Recommendation Report for Planning Permission for Works or Extension to a Dwelling

REF NO: A/62/21/HH

LOCATION: 8 Lavender Way
Angmering
BN16 4QD

PROPOSAL: Erection of a small one storey extension to the rear of the property.

PROPOSED GROUND FLOOR PLAN 1:50

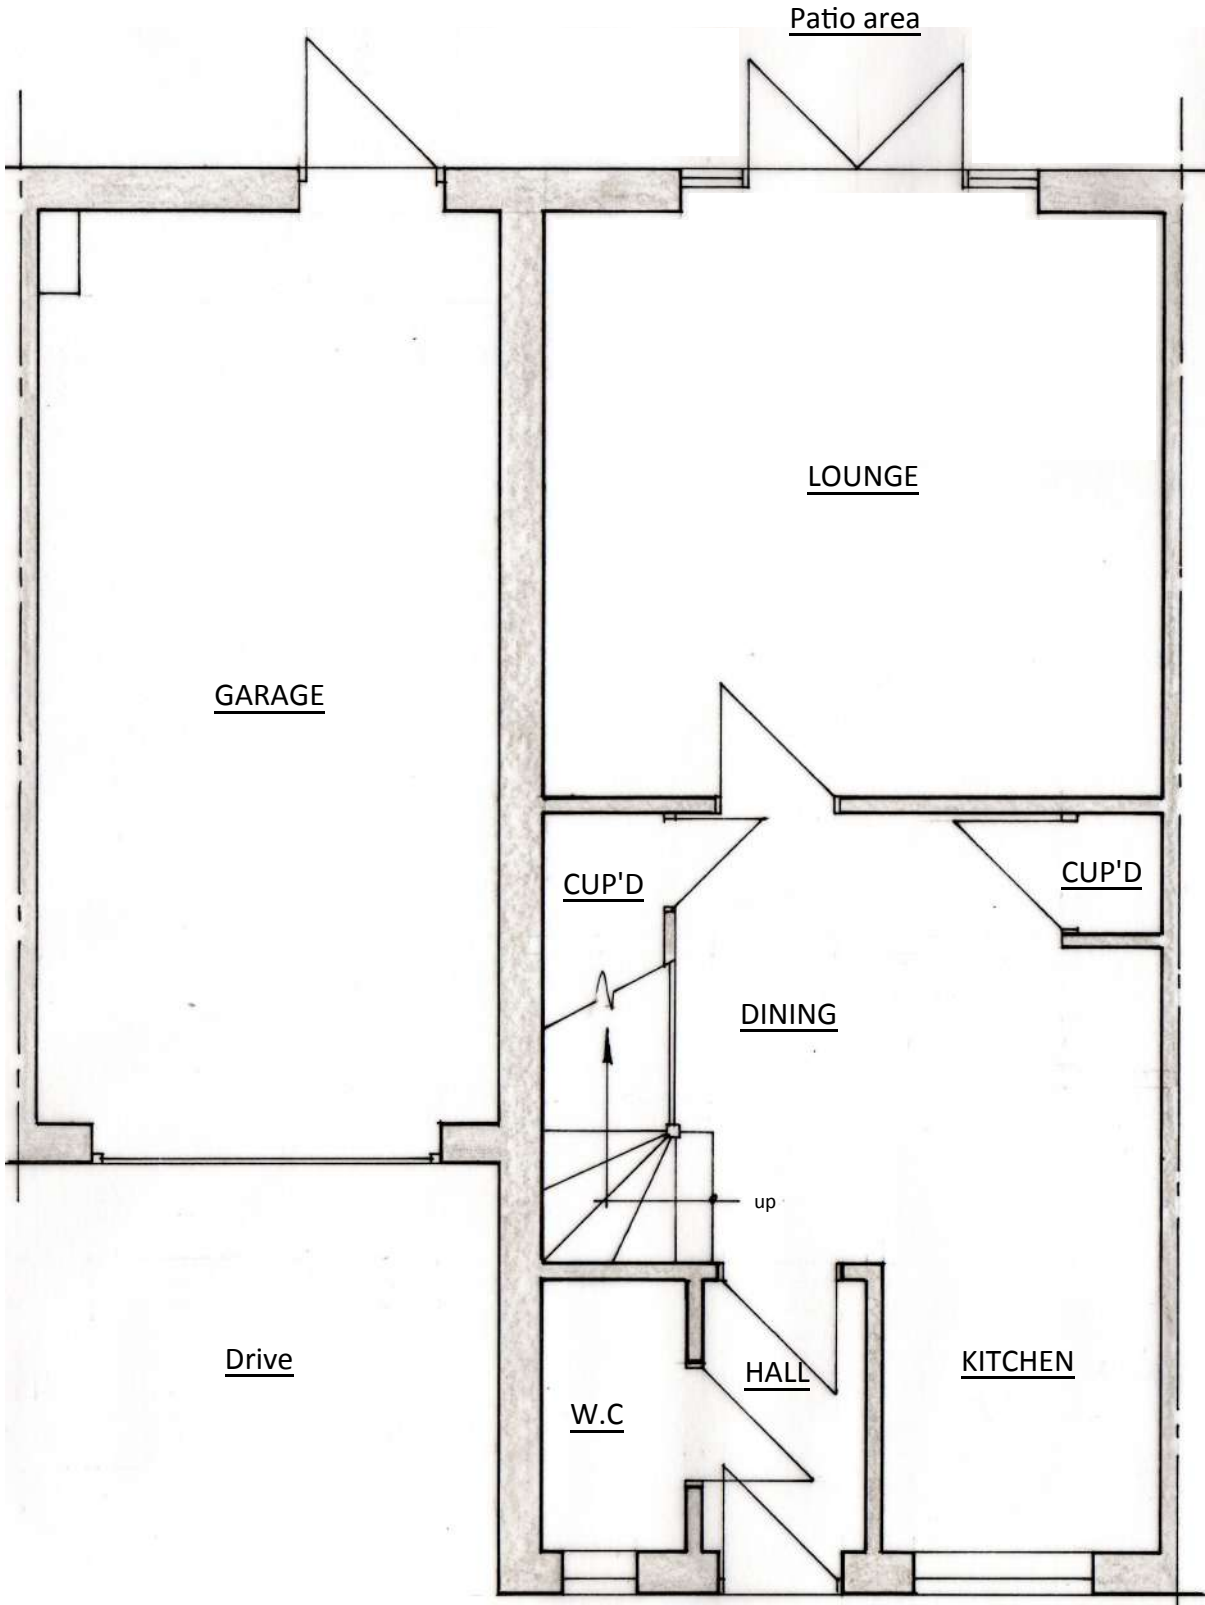
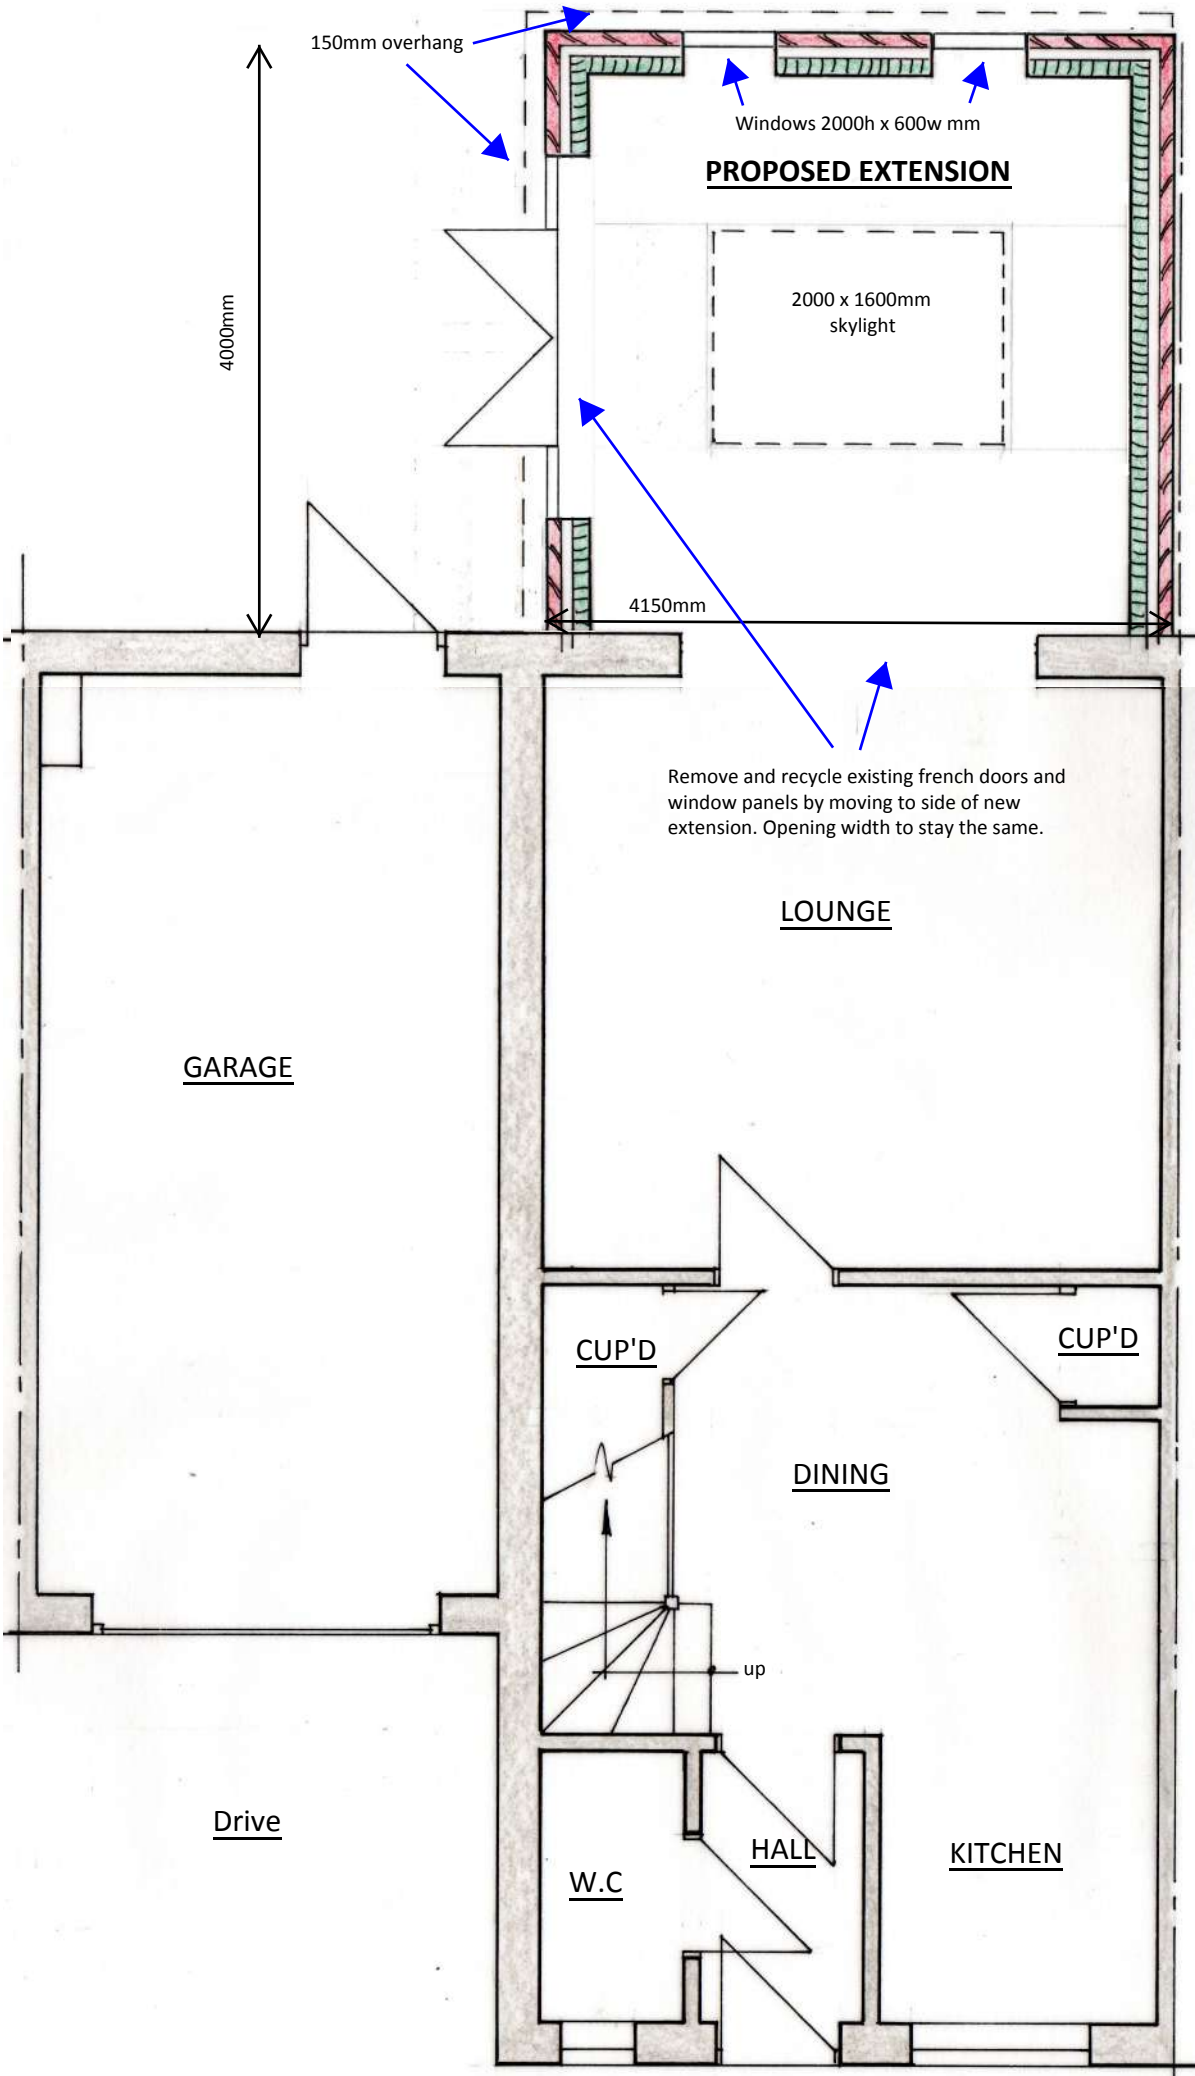
In terms of overshadowing and overbearing, the extension will not unacceptably impact on neighbouring properties. The dwelling sits in a terrace of dwellings and the extension is to the rear (south elevation). The extension is to be located against its western boundary, shared with No. 6 Lavender Way.

When considering the 45-degree rule, the extension is expected just to sit outside of the allowed amount, however as the properties have south facing rear gardens sufficient levels of light are still expected to reach the neighbours' windows. As the extension is located to the south of the host dwelling, levels of shading to the rear gardens of the adjoining properties will occur, especially to No. 6 in the morning. However, it is considered acceptable as a rear extension of up to 3m could be permissible under the properties Permitted Development Rights.

PROPOSED REAR ELEVATION (SOUTH) 1:50

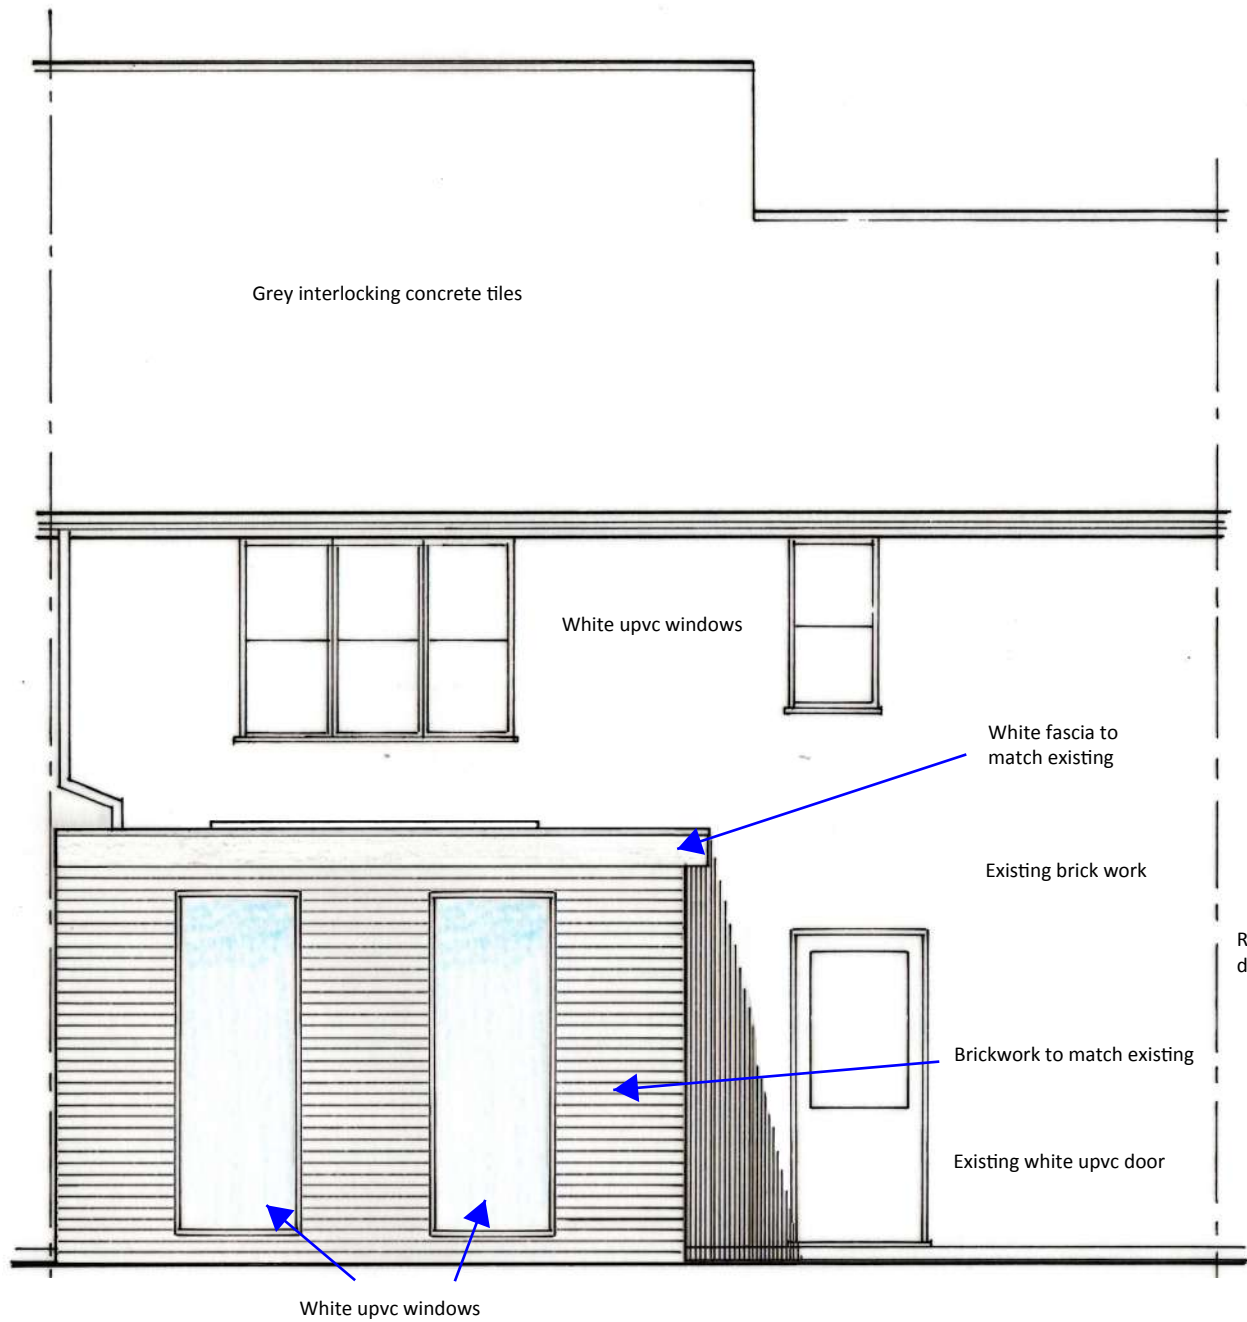
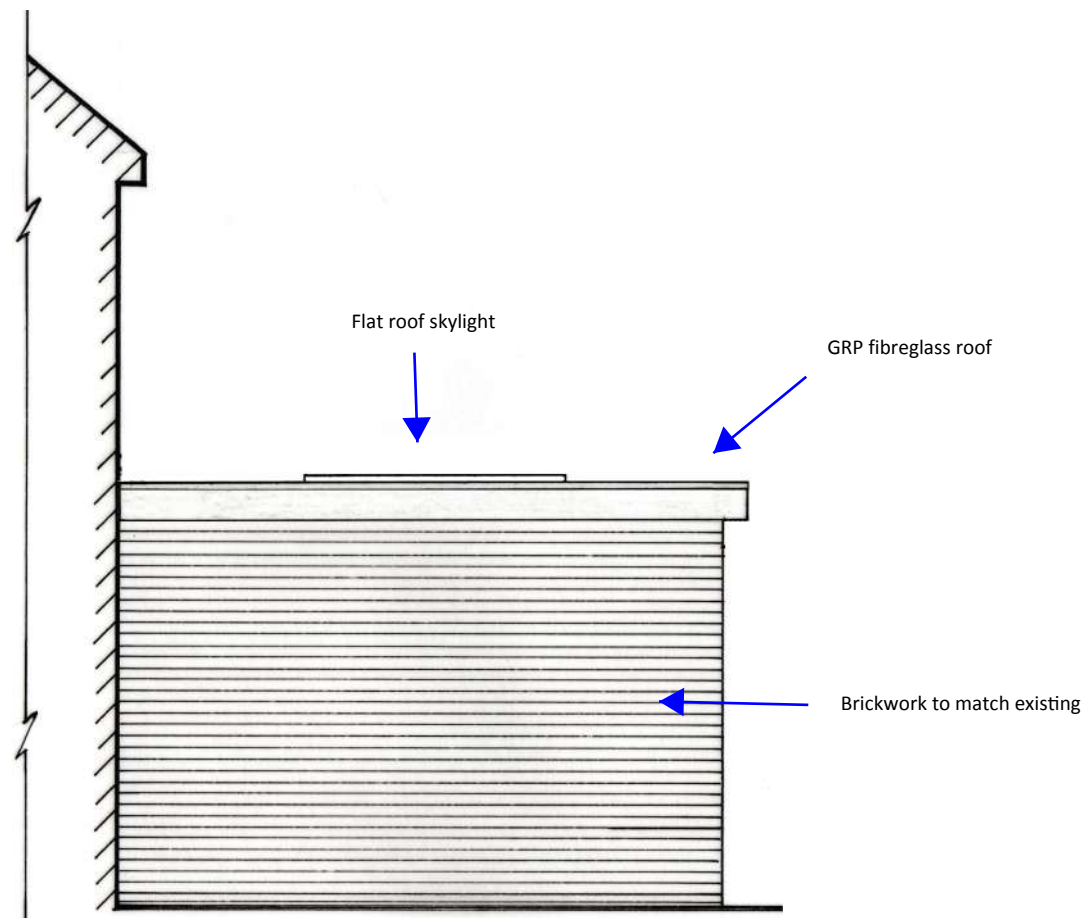
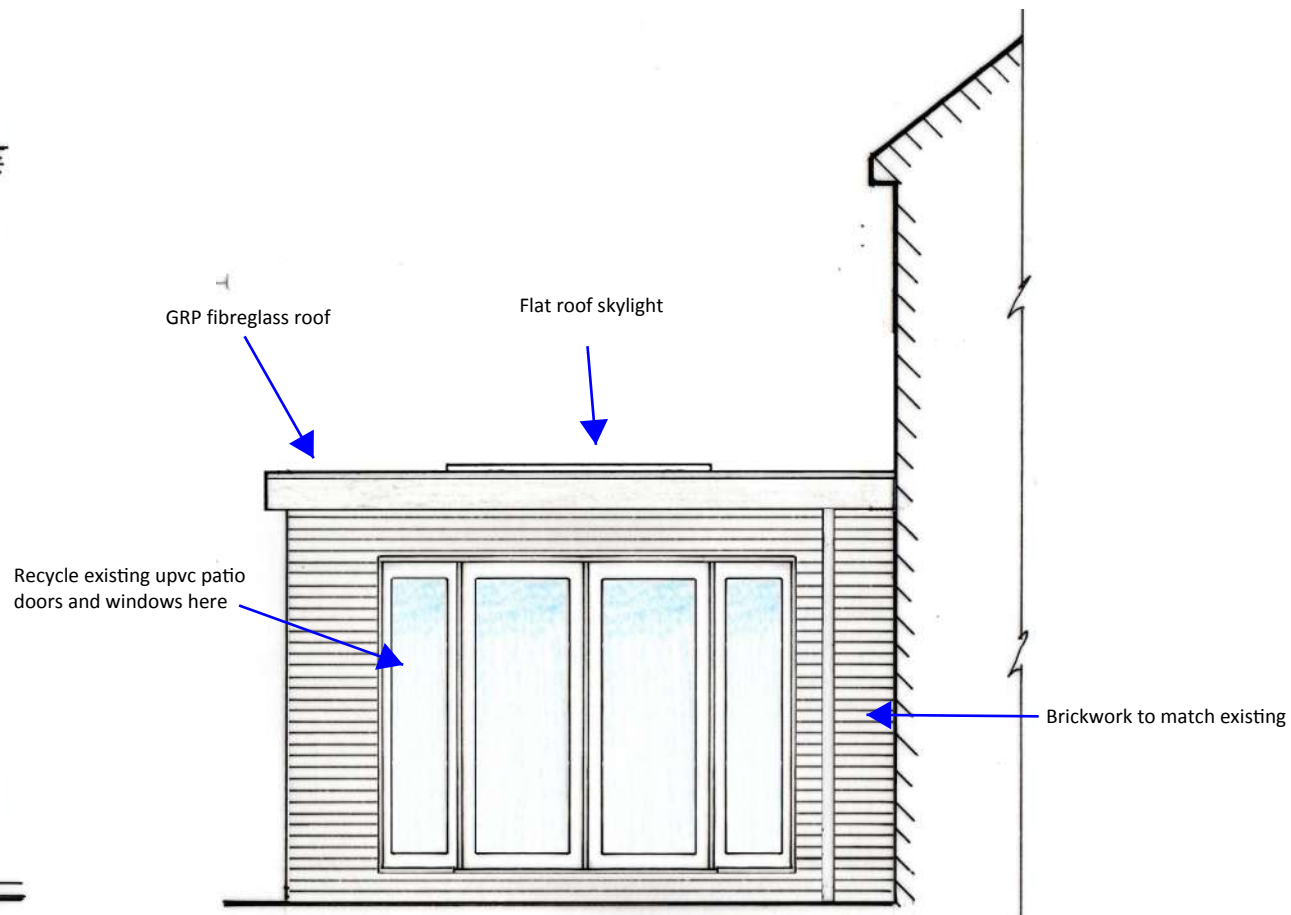
The extension is to project from the rear elevation and provide additional living space for the occupants. Its scale is appropriate when compared to the dwelling. The eaves are to be considerably lower than those currently found on the two-storey dwelling. The extension is of materials which match the host dwelling and relates well to the modern style found on site and in the surrounding area. The extension will not be visible from the street.

In terms of overlooking new fenestration has been proposed to face the rear amenity space of the property only and is therefore acceptable.
